**City of Portland, Maine - Building or Use Permit Application**  
 389 Congress Street, 04101 Tel: (207) 874-8703, Fax: (207) 874-8716

<b>Permit No:</b> 09-1081	<b>Issue Date:</b>	<b>CBL:</b> 116 D001001
------------------------------	--------------------	----------------------------

<b>Past Use:</b> Commercial - Restaurant connected w/ permit# 090940	<b>Proposed Use:</b> Commercial - Restaurant - install a 8' and 20' Hood system w/ make-up air	<b>Permit Fee:</b>	<b>Cost of Work:</b> \$17,500.00	<b>CEO District:</b> 2
<b>Proposed Project Description:</b> install a 8' and 20' Hood system w/ make-up air		<b>FIRE DEPT:</b> <input type="checkbox"/> Approved <input type="checkbox"/> Denied	<b>INSPECTION:</b> Use Group: Type	
		Signature:	Signature:	
<b>PEDESTRIAN ACTIVITIES DISTRICT (P.A.D.)</b>				
Action <input type="checkbox"/> Approved <input type="checkbox"/> Approved w/Condition <input type="checkbox"/> Denied				
		Signature:	Date:

General Hood Arrangement  
 408 Forest Ave.  
 Contractor: Lebel's Steel Metal  
 Contact: PAUL ROY  
 Tel: 207-782-2235

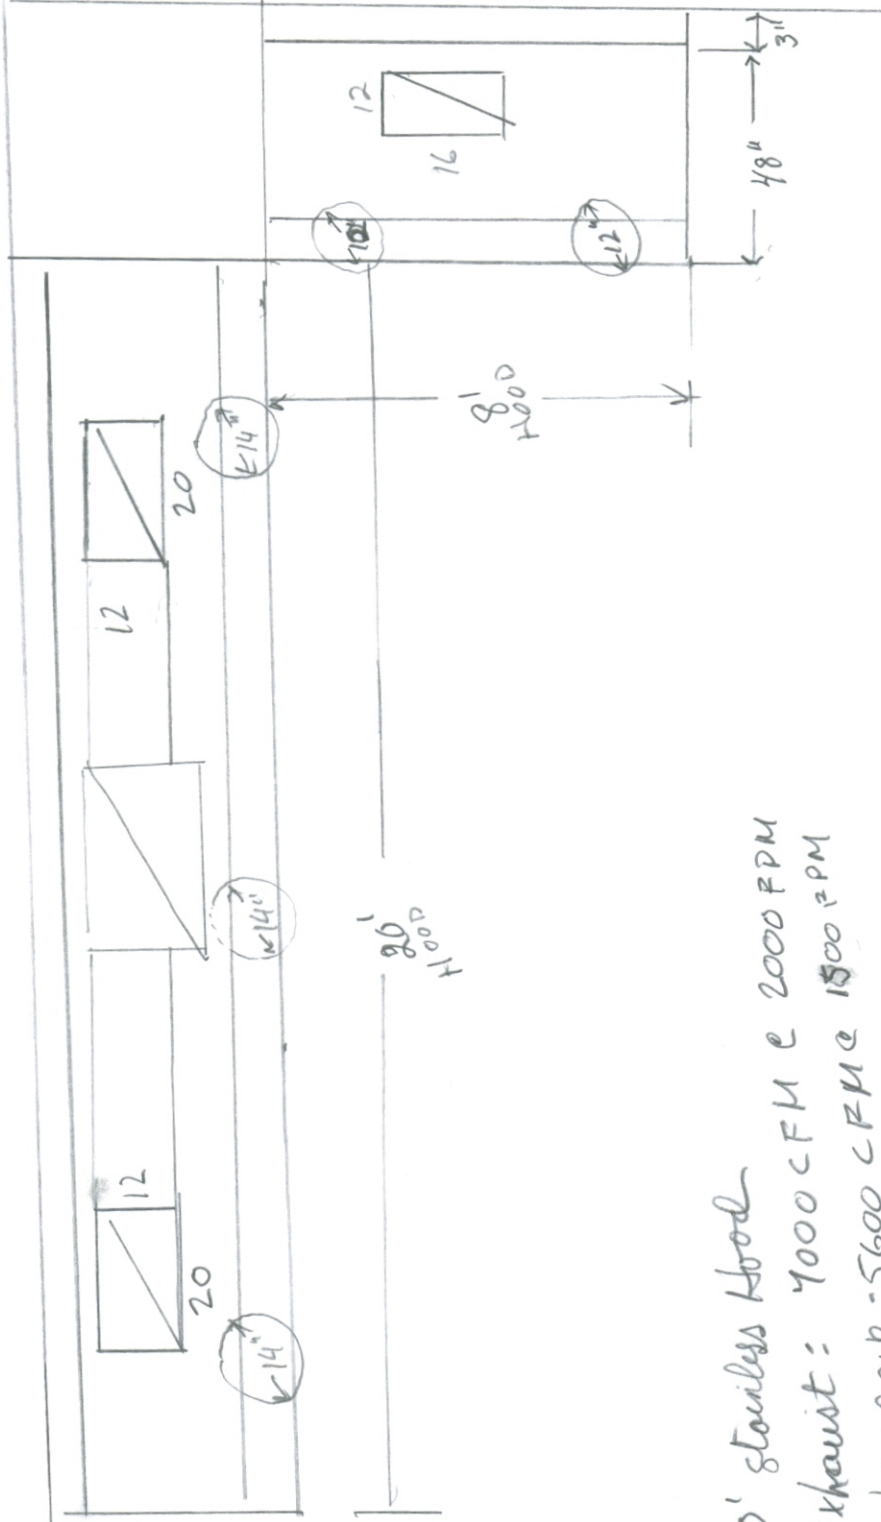
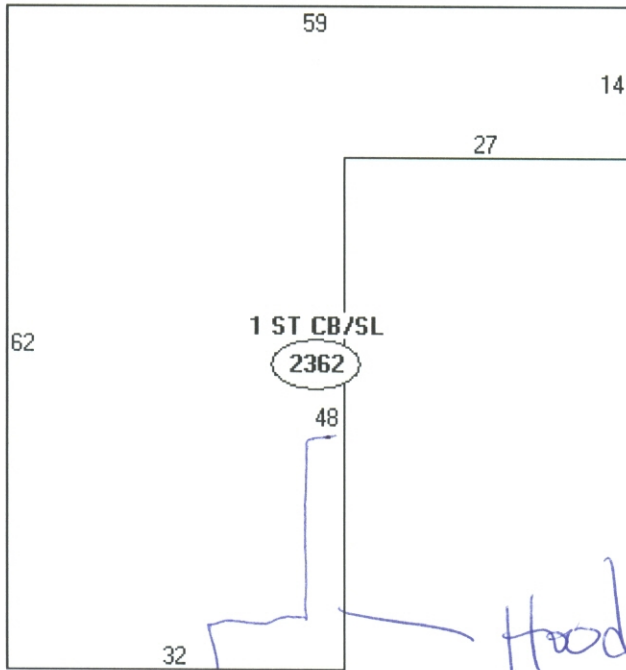
11/10/2009-jmb: Left vcmmsg with Paul R. For dimension from hood to combustible roof structure. Building has masonry walls. Paull R. Called back to confirm there is 18" to the ceiling, ok to issue told needed final inspection
